From: Laura Gibbons <Laura.Gibbons@arun.gov.uk>
Sent: 12 October 2021 14:06
To: Planning.Responses <Planning.Responses@arun.gov.uk>
Cc: Simon Davis <Simon.Davis@arun.gov.uk>
Subject: FW: Planning Consultation on: A/210/21/DOC

Thank you for consulting us regarding this discharge of conditions application, we have the following comments regarding Conditions 15, 16, 17, and 21.

Application No: A/210/21/DOC

Description of Works: Approval of details reserved by condition imposed under ref A/114/185/PL relating to Condition Nos 15 - surface water drainage, 16 - discharge flows to watercourses, 17 - maintenance & management of surface water drainage and 21 - access & maintenance of any watercourse or culvert.

CELLULAR ATTENUATION DETAIL
(REFER TO DRAINAGE LAYOUT FOR SITE SPECIFIC DETAIL)

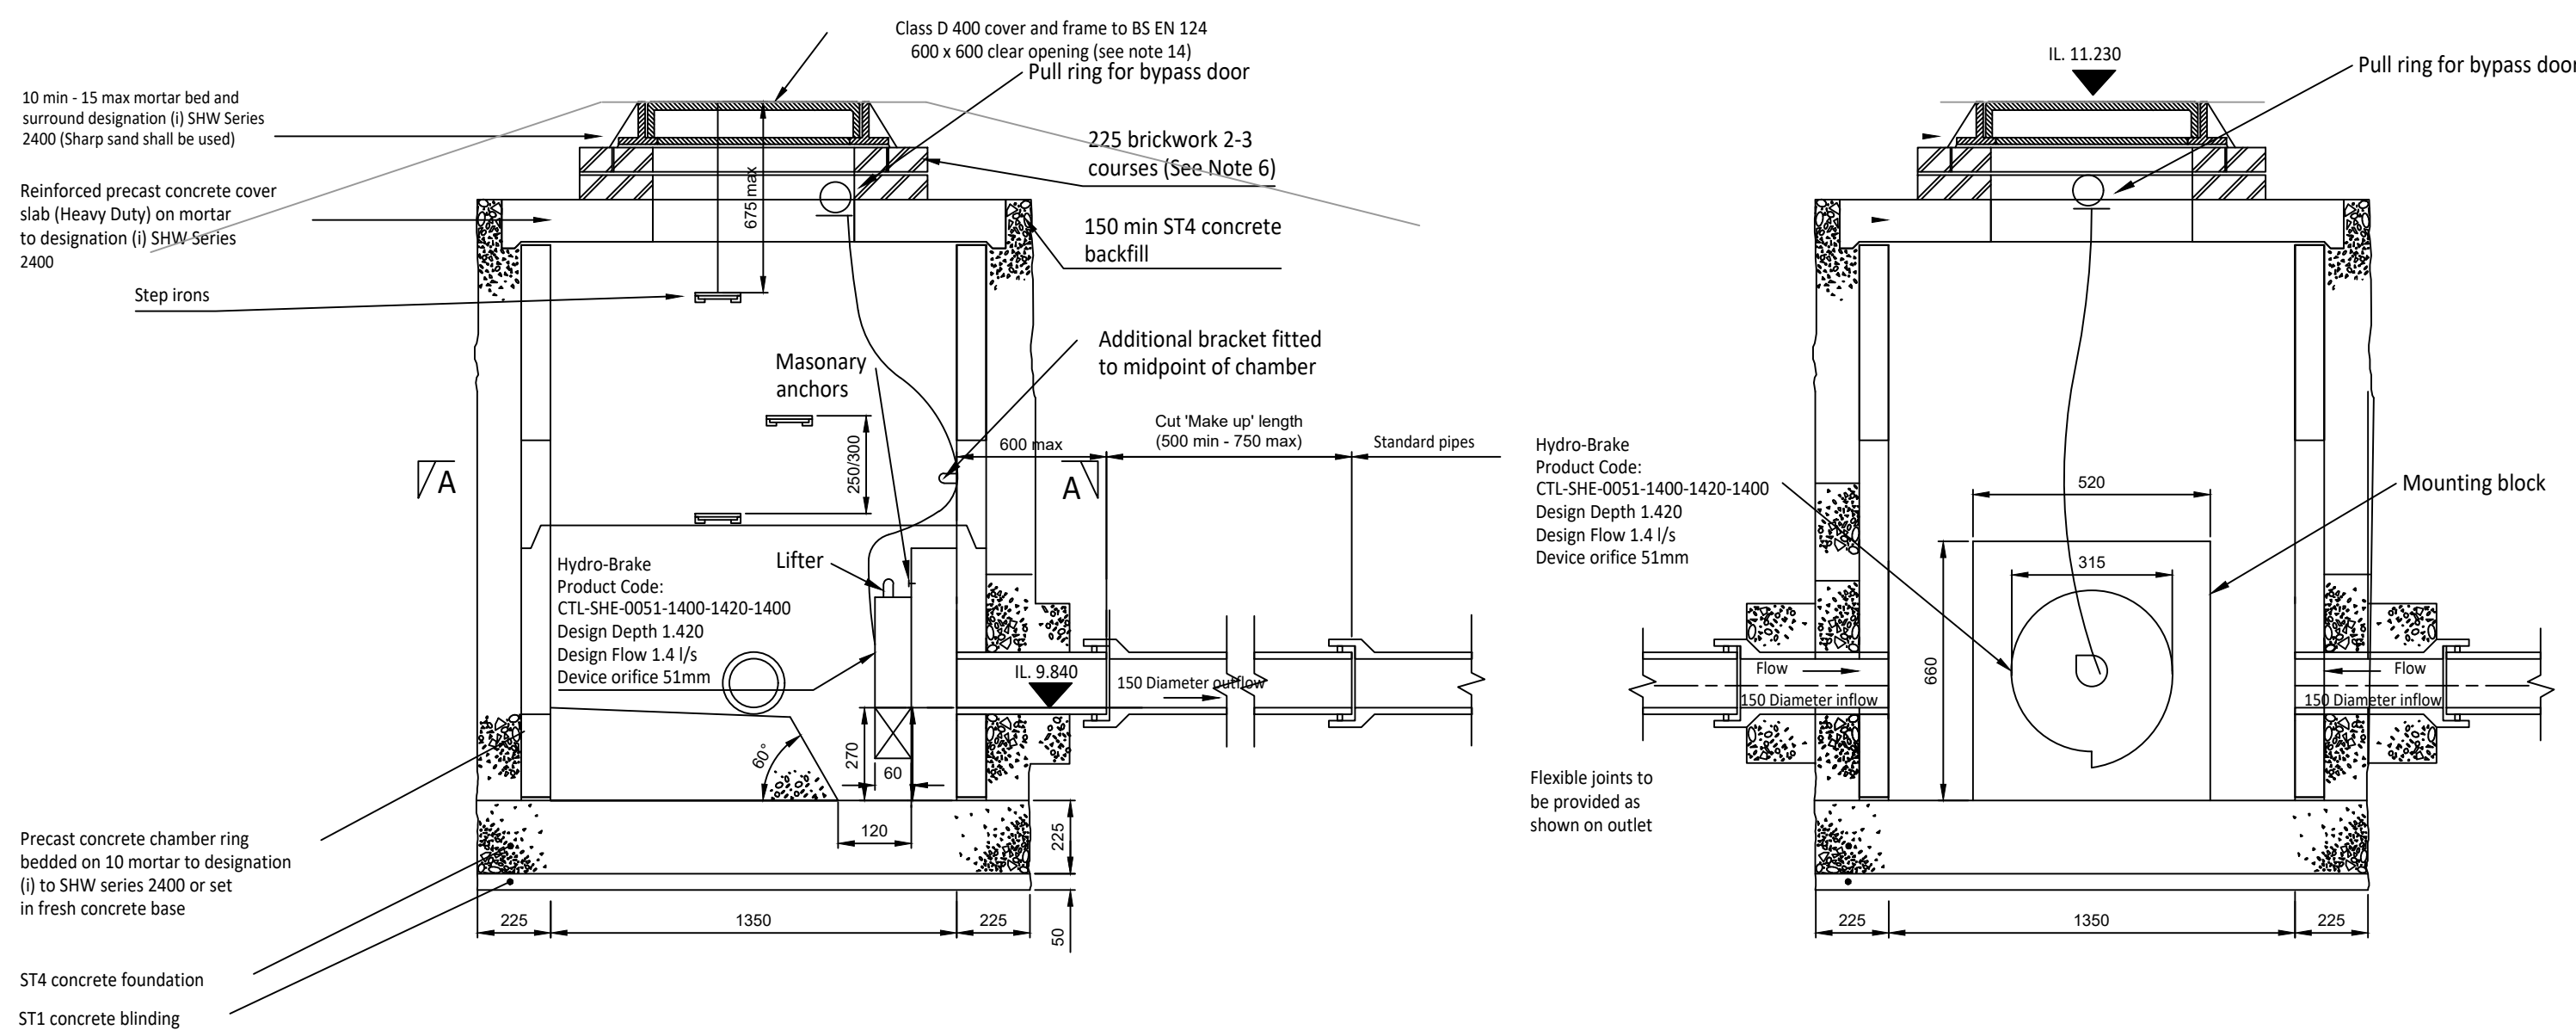
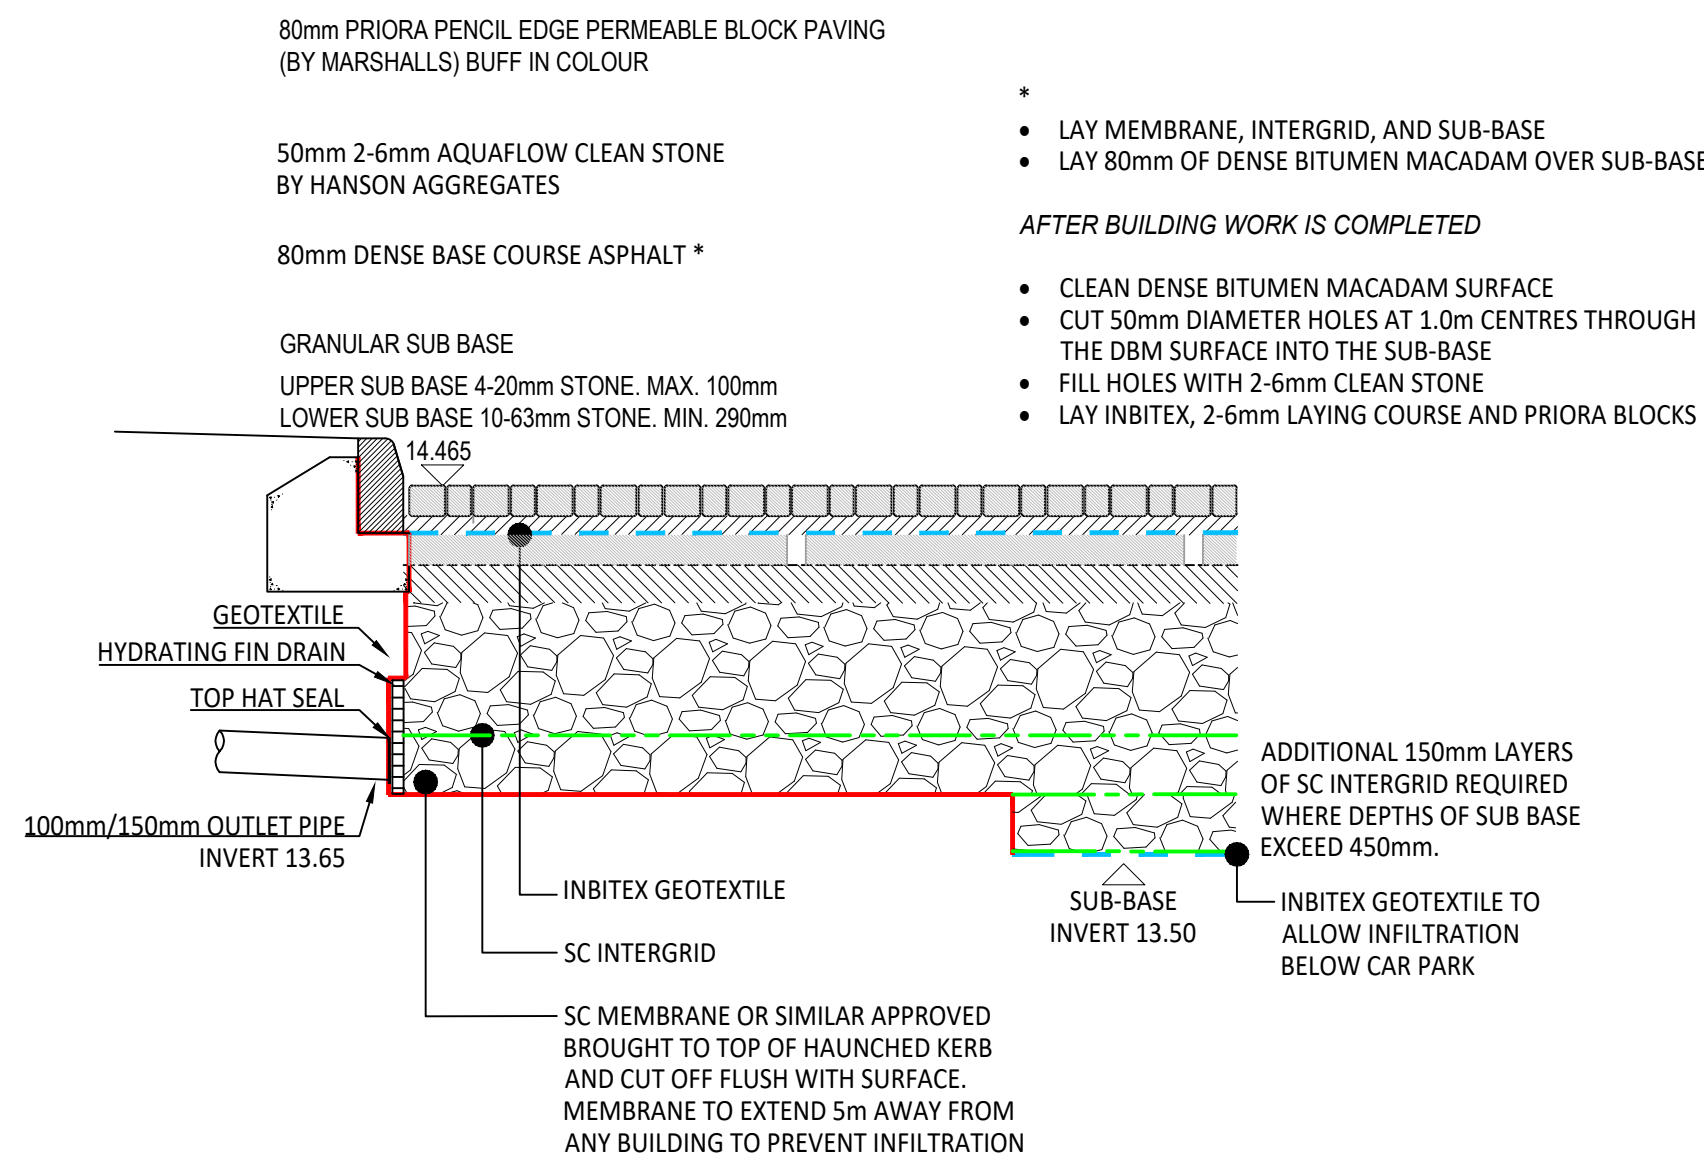
Please supply a construction detail drawing of the distribution tanks within the permeable sub-base.

PERMEABLE BLOCK PAVED CAR PARK & DISTRIBUTION TANK DETAIL

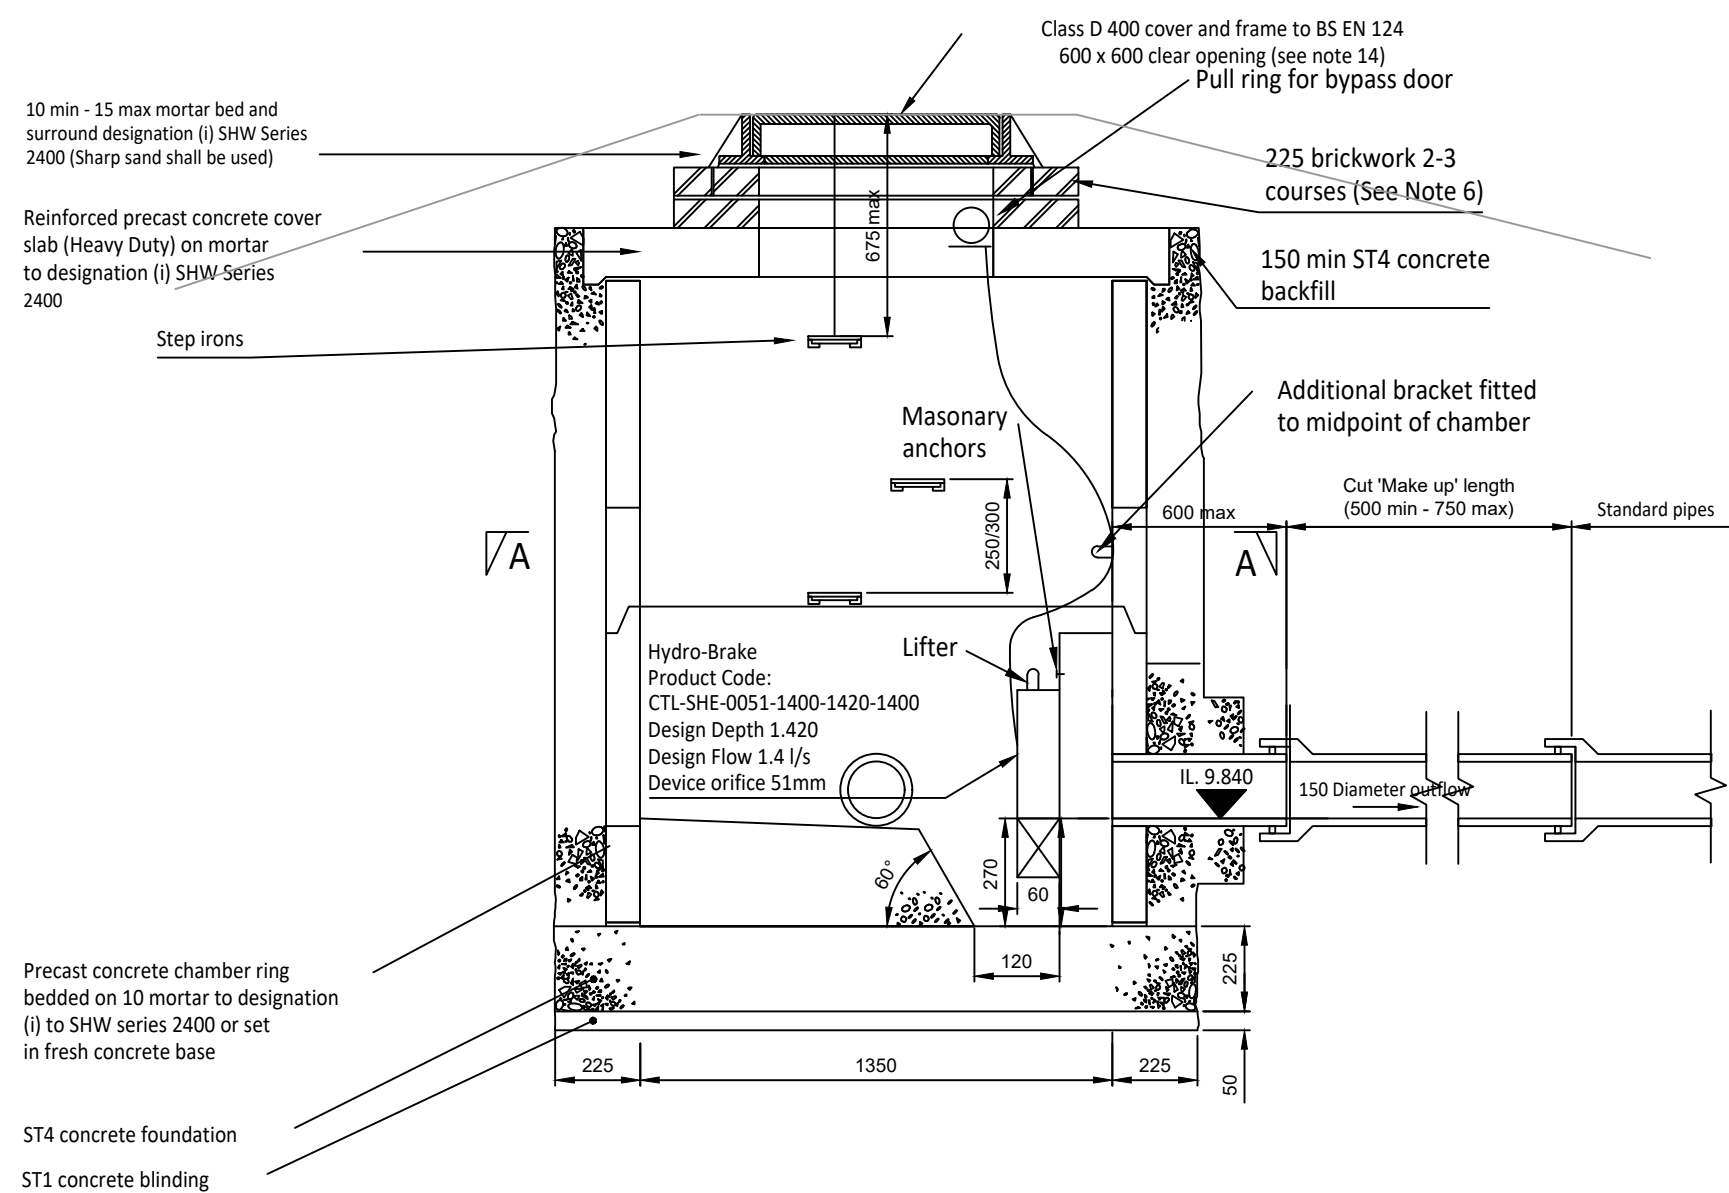
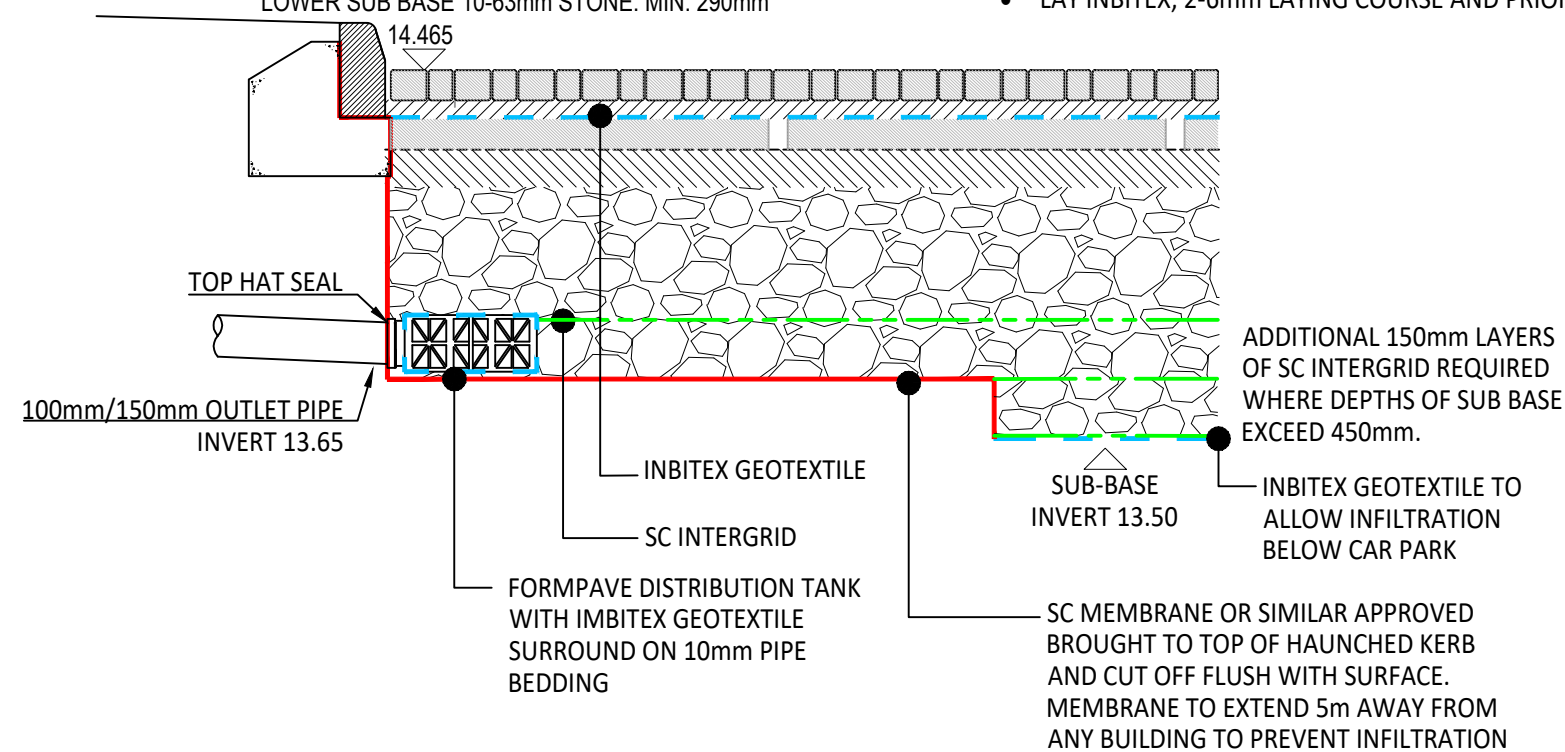
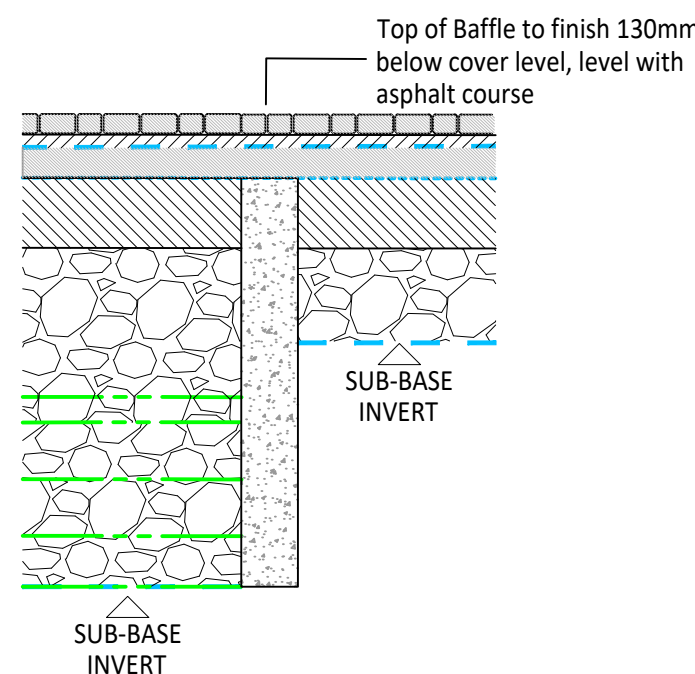
Please provide a construction detail drawing of the permeable paving which is shown not to have a permeable sub-base.
